Your ref: SSD-31179510
Our ref: DOC25/1094210

Subject: Response to Submissions Amendment Report – Gregory Place Build-to-Rent located at 2A Gregory Place, Harris Park (SSD-31179510)

CPHR advice on RTS Amendment Report - Gregory Place Build-to-Rent located at 2A Gregory Place, Harris Park (SSD-31179510)

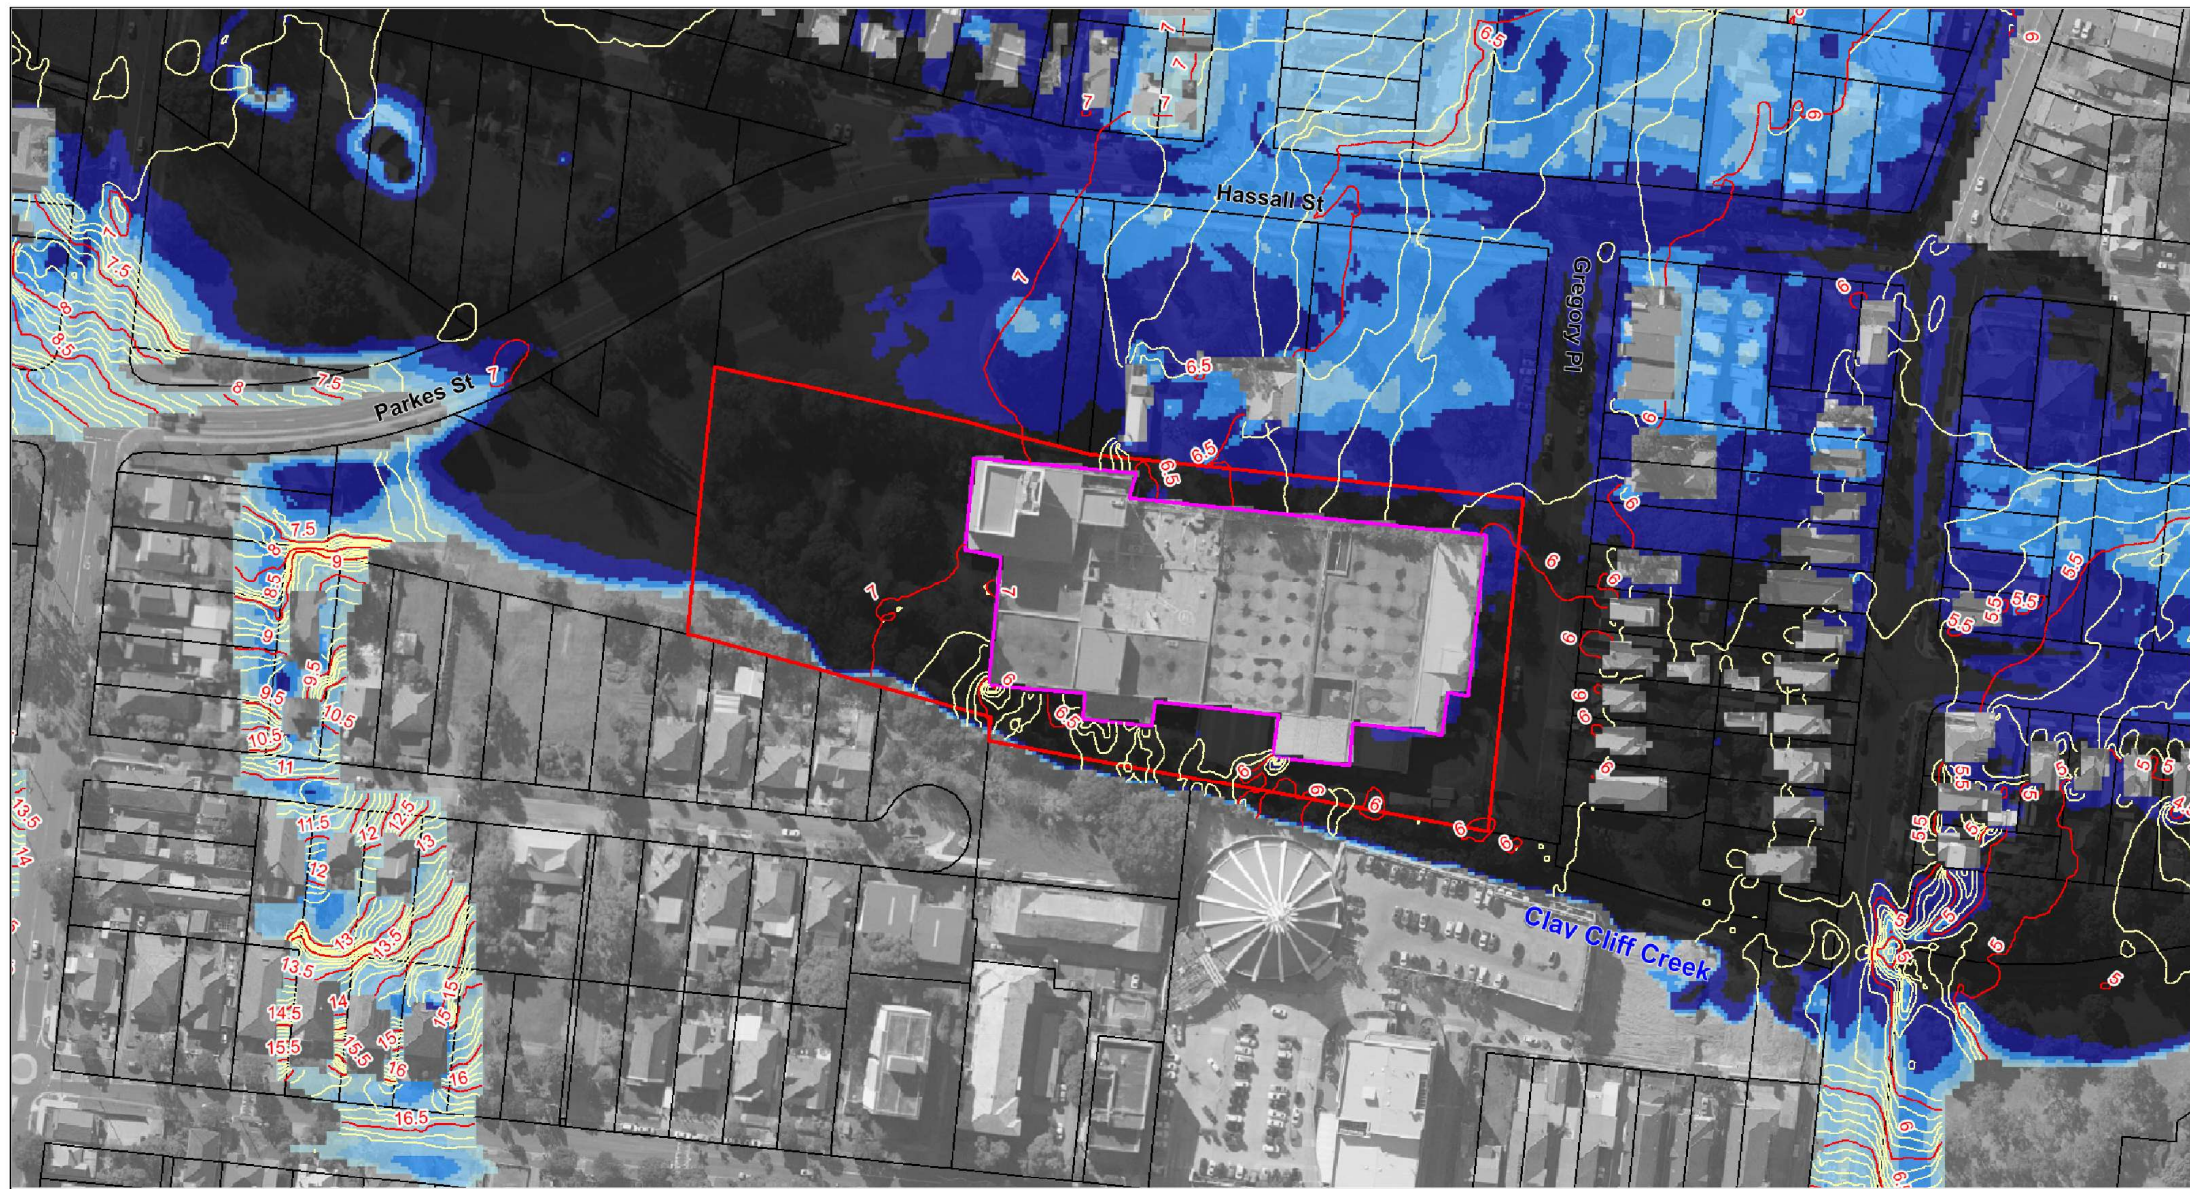
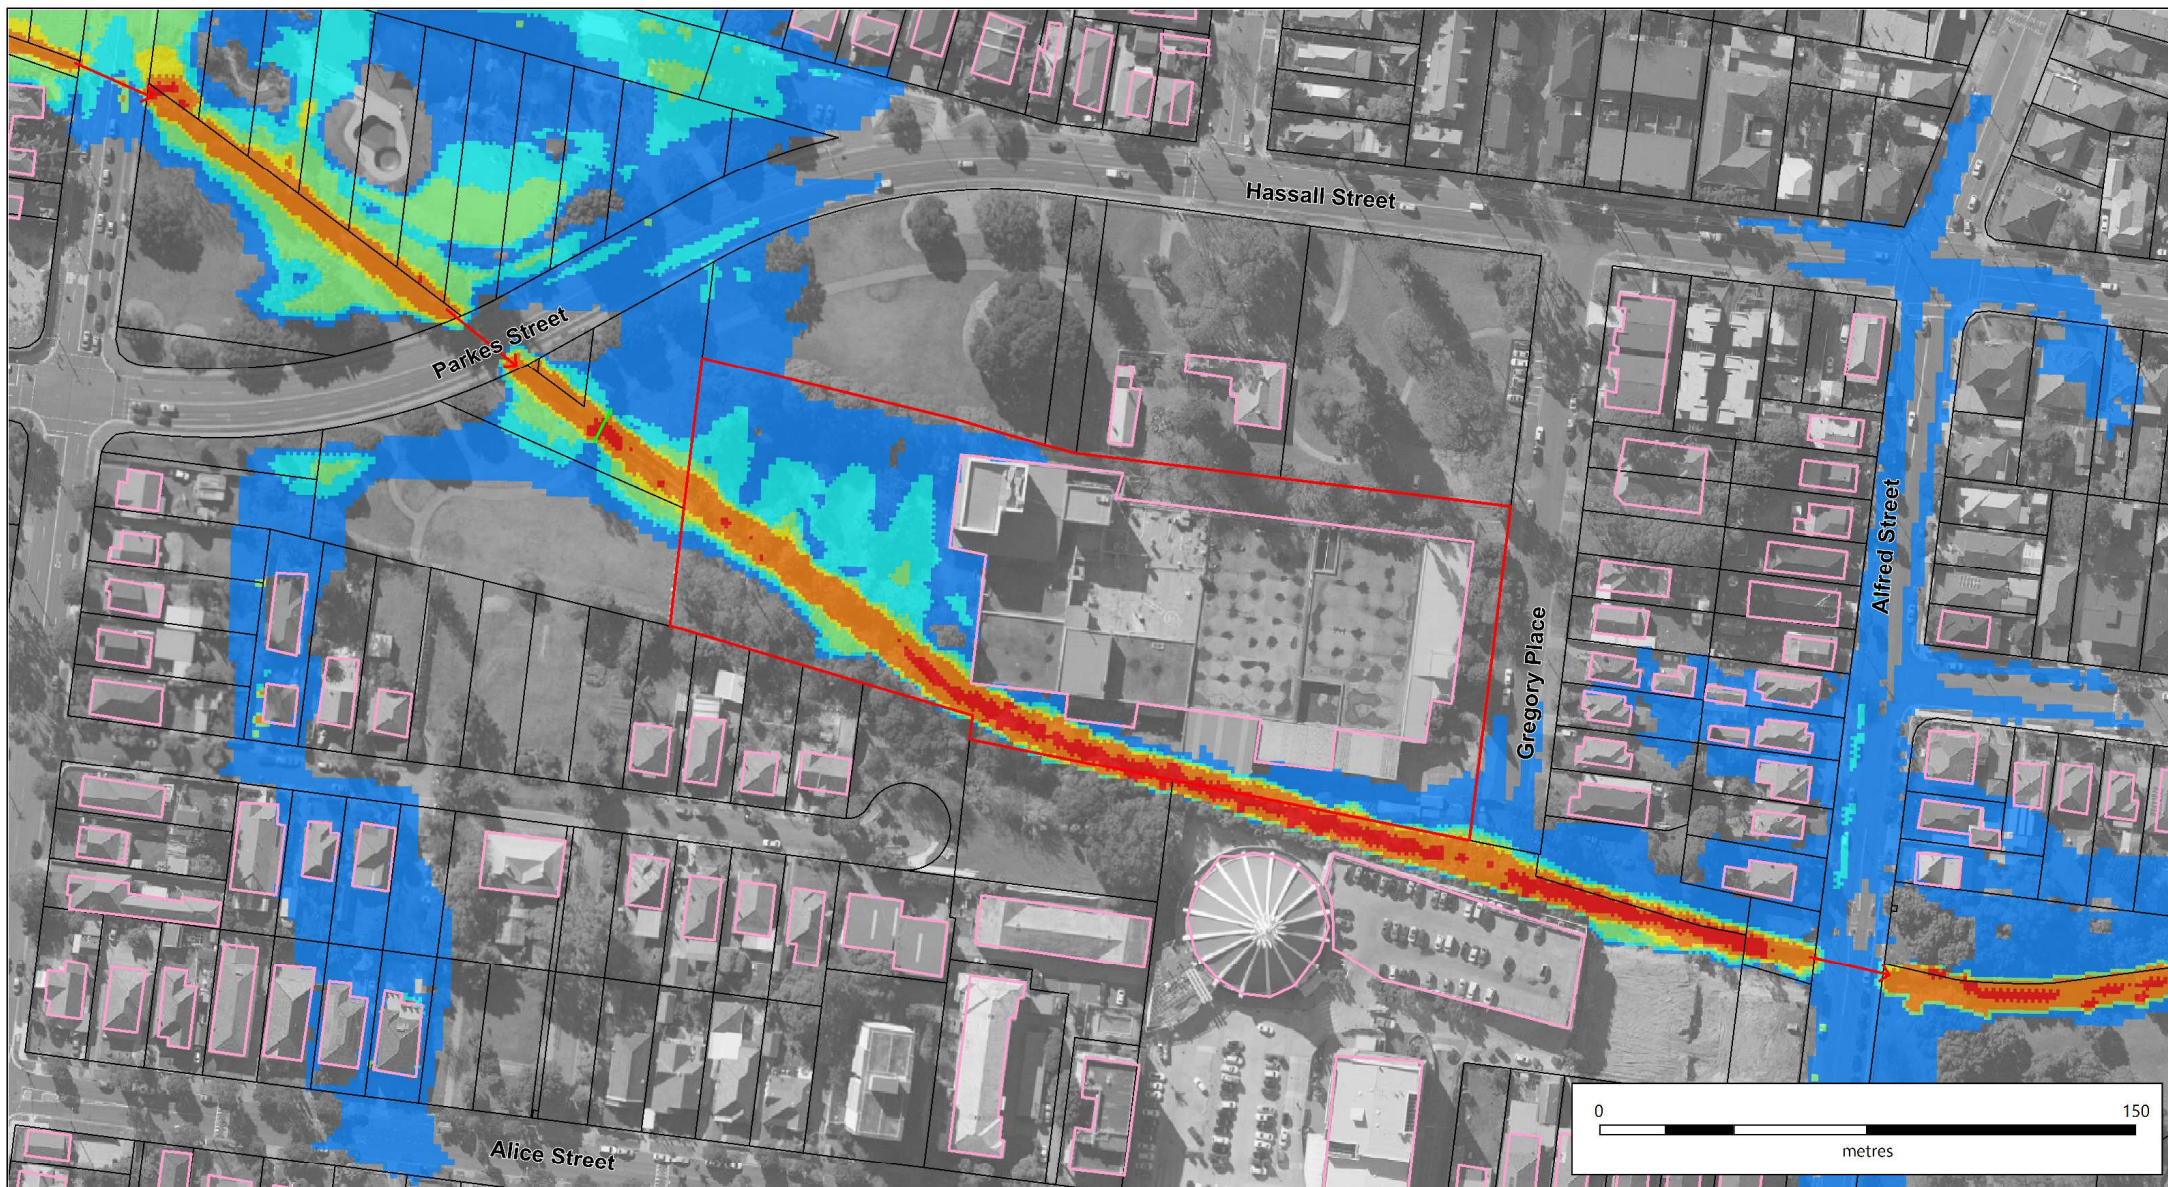
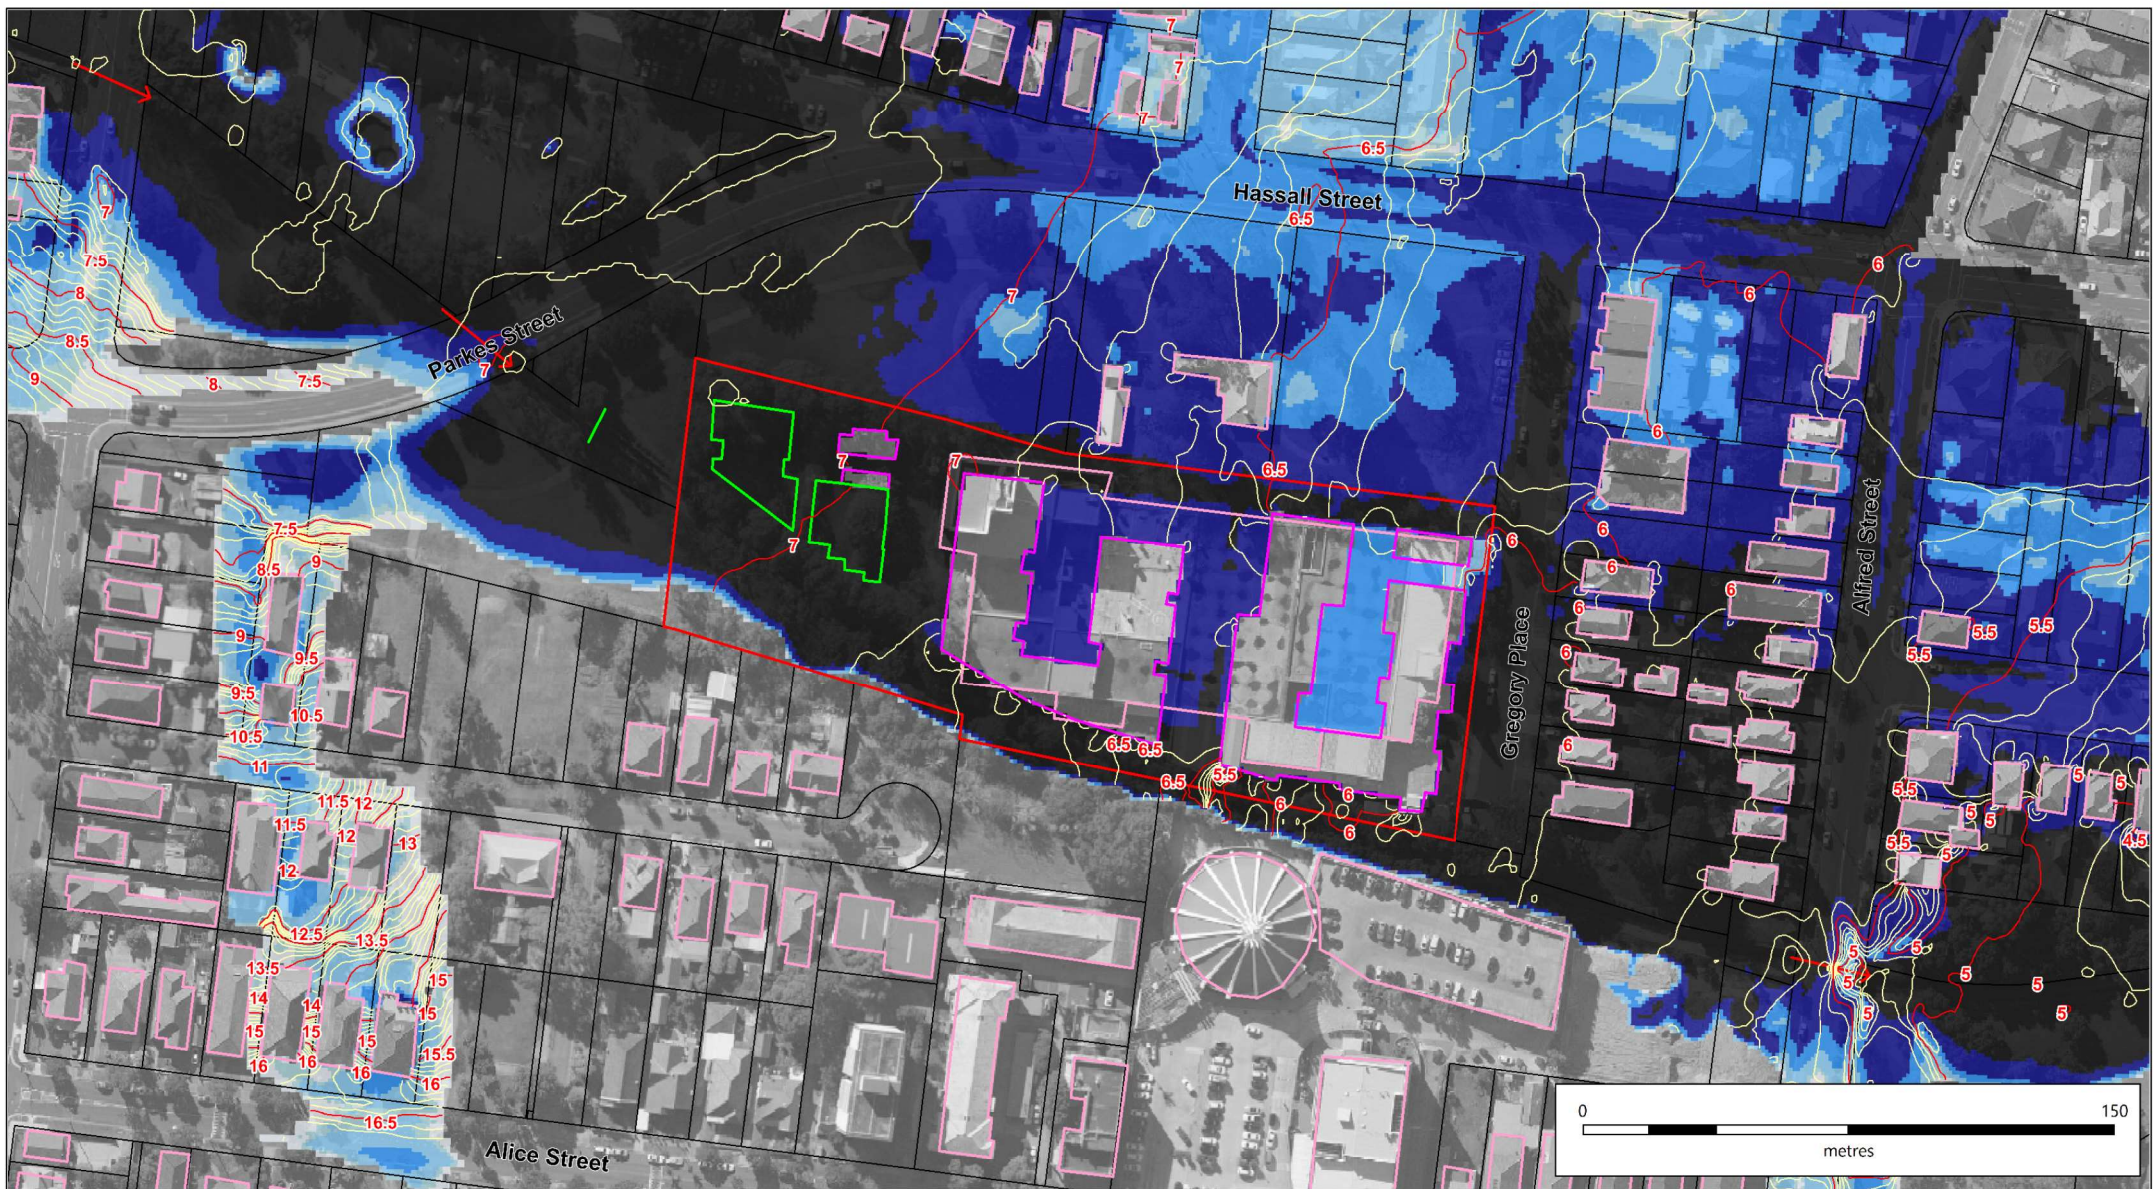
<i>Extent and Timing</i>	Pre-determination
2	<i>Flood impacts</i>	PMF impacts have not been mapped as required. Recommended action: Map and discuss flood impacts in the PMF separately for the Clay Cliff Creek and the Parramatta River.
	<i>Extent and Timing</i>	Pre-determination
3	<i>Flood risk</i>	While the FERP has used results of Council's Parramatta River Flood Study (Stantec, 13 June 2024) for the Parramatta River PMF, the Updated Flood Assessment has not presented mapping or discussion of Parramatta River PMF. The site is currently used for industry, and the proposal is for residential development. Given the highly constrained nature of the site, detailed consideration should be given to the suitability of the site for residential use. Residential use carries a higher flood risk profile than employment uses including longer and overnight occupation and the potential higher vulnerability of occupants such as children. Industrial facilities can close early before a flood and can be evacuated more easily. Recommended action: • Provide mapping and discussion of Parramatta River PMF and how it impacts use of the site. • Provide detailed consideration as to the suitability of the site for residential development.
